DRB Project Number: 1007502
Seven Bar Ranch

SUBJECT: Preliminary/ Final Plat

Project: #1007502-17DRB-700342

Meeting Date: March 21, 2018

PLAT OF
TRACT M-1-B-2-A
SEVEN-BAR RANCH
WITHIN THE
TOWN OF ALAMEDA GRANT
PROJECTED SECTION 7,
TOWNSHIP 11 NORTH, RANGE 3 EAST, N.M.P.M.
CITY OF ALBUQUERQUE
BERNALILLO COUNTY, NEW MEXICO
FEBRUARY, 2018

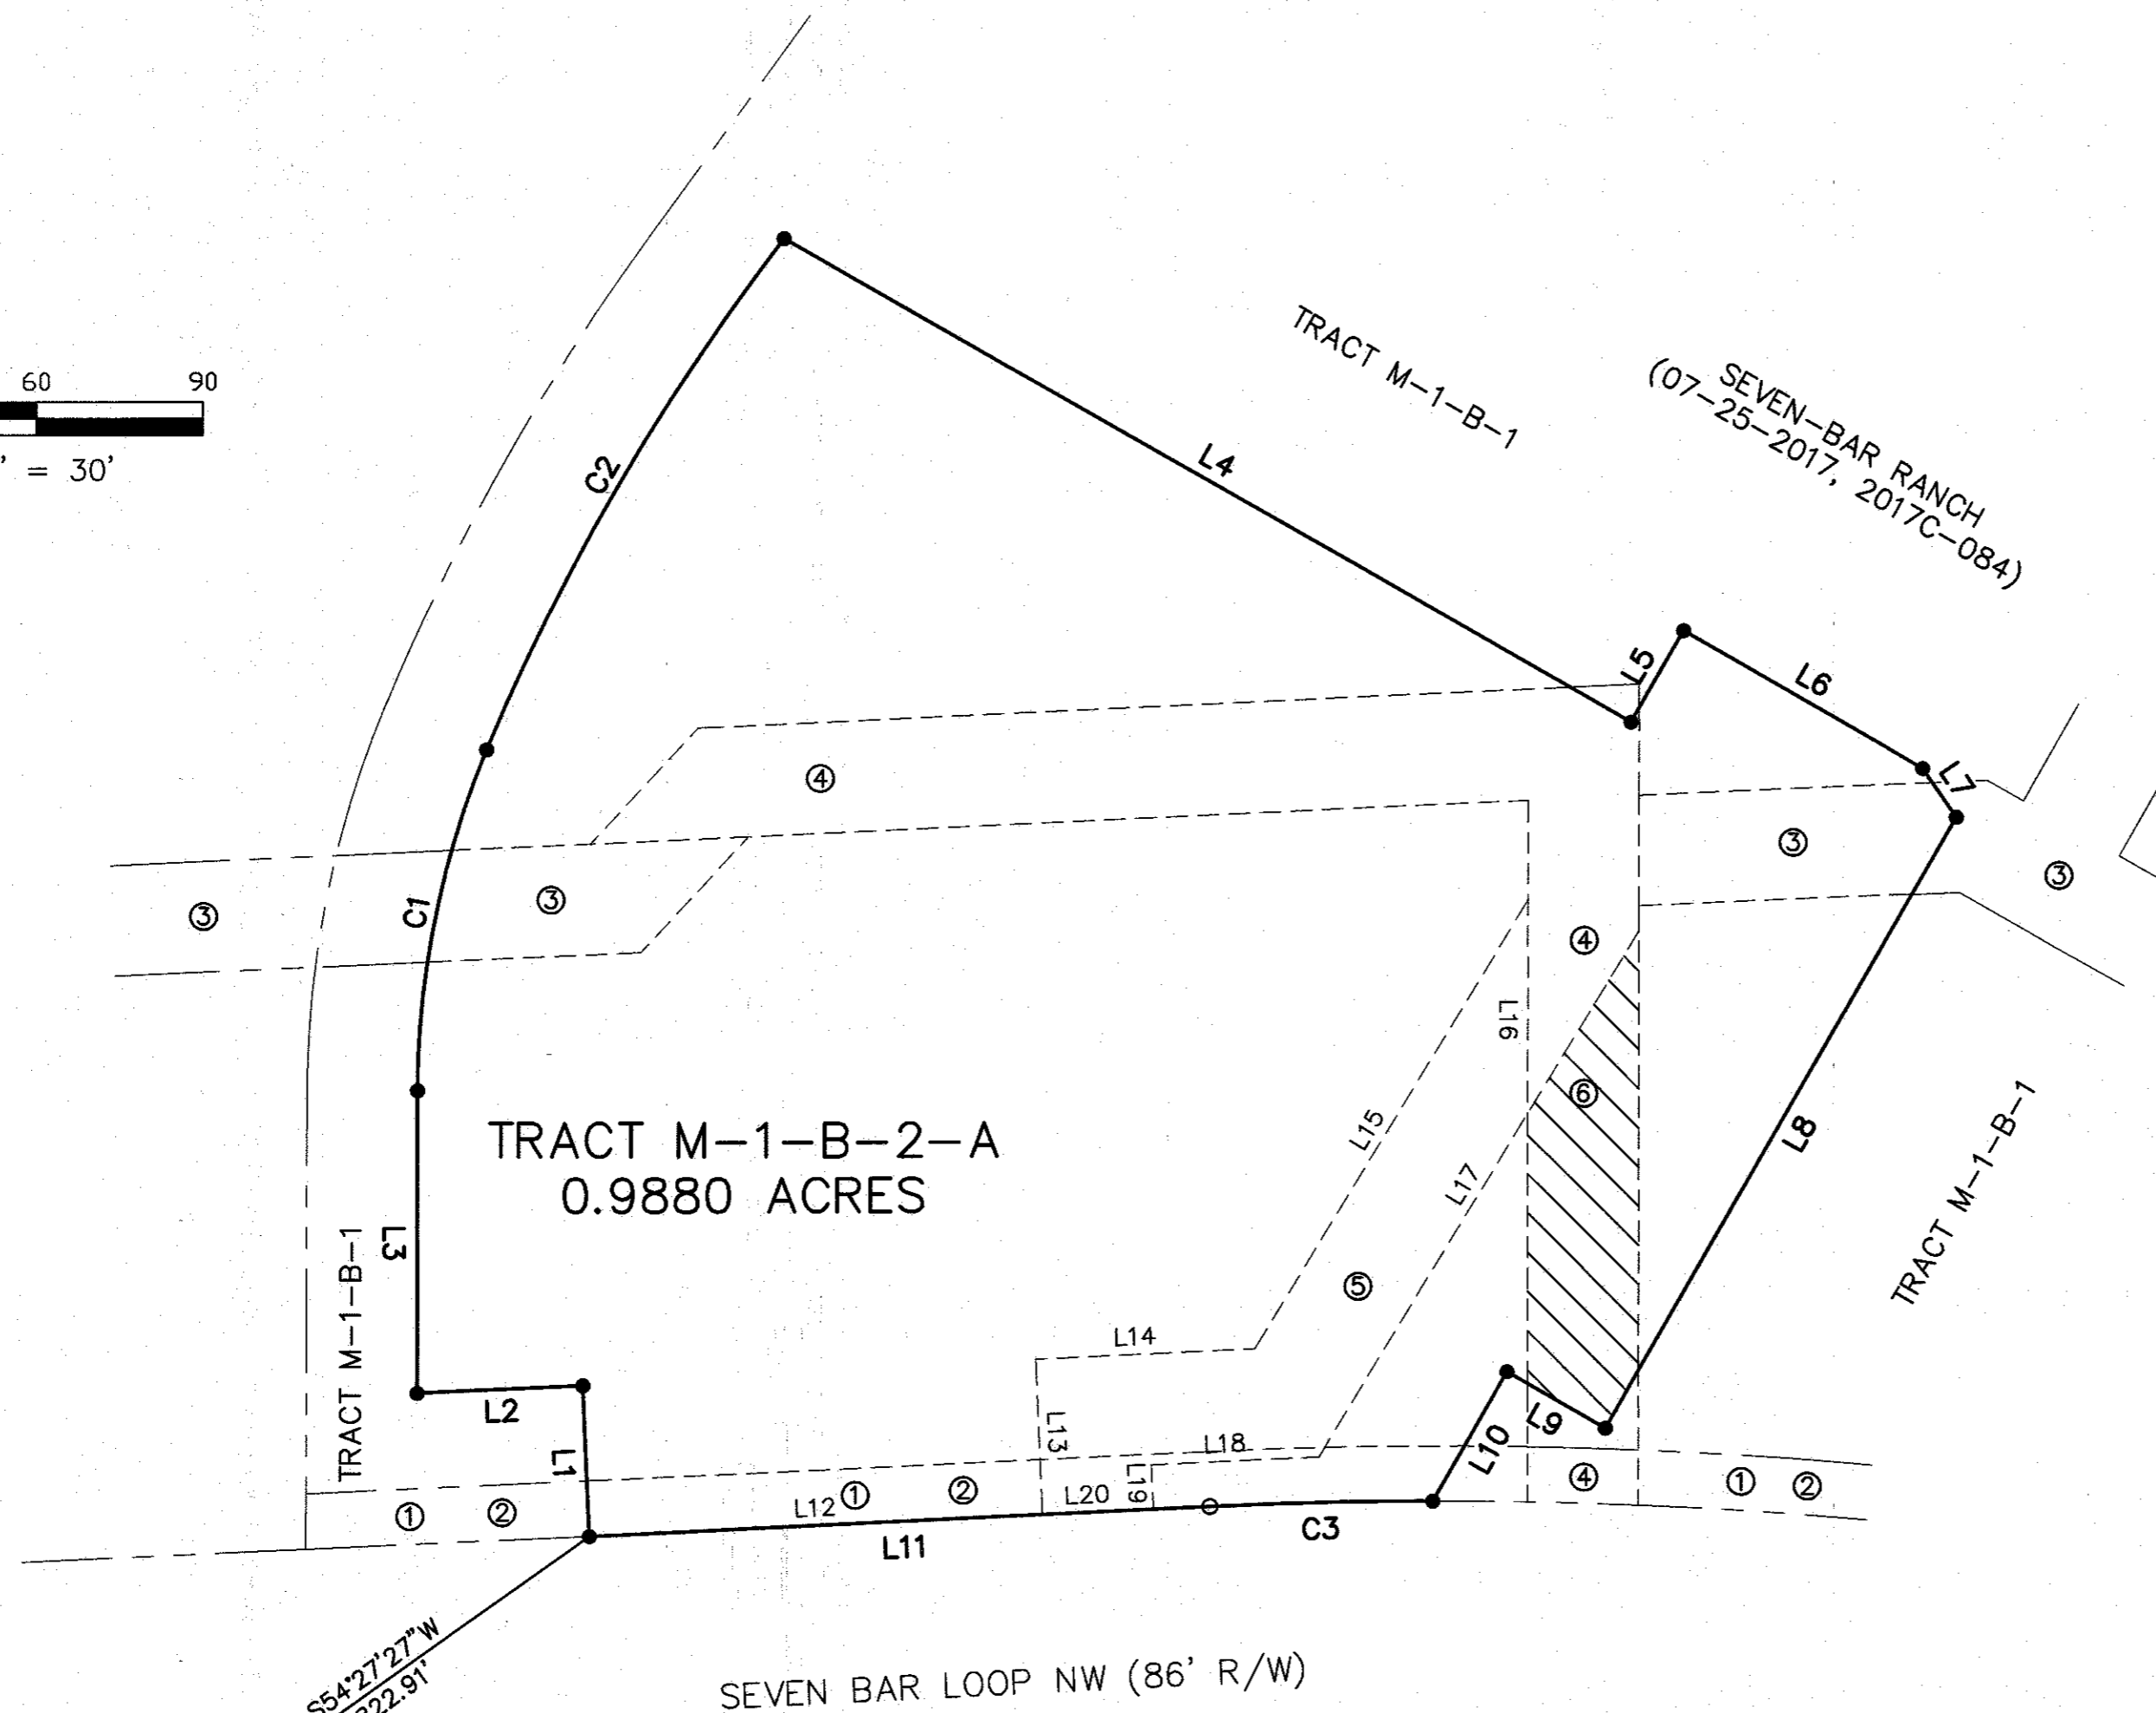
- No objection to the plat.
- Make sure to list the vacation information and area of vacated esmt
- Make sure the purpose of the plat includes the vacation action
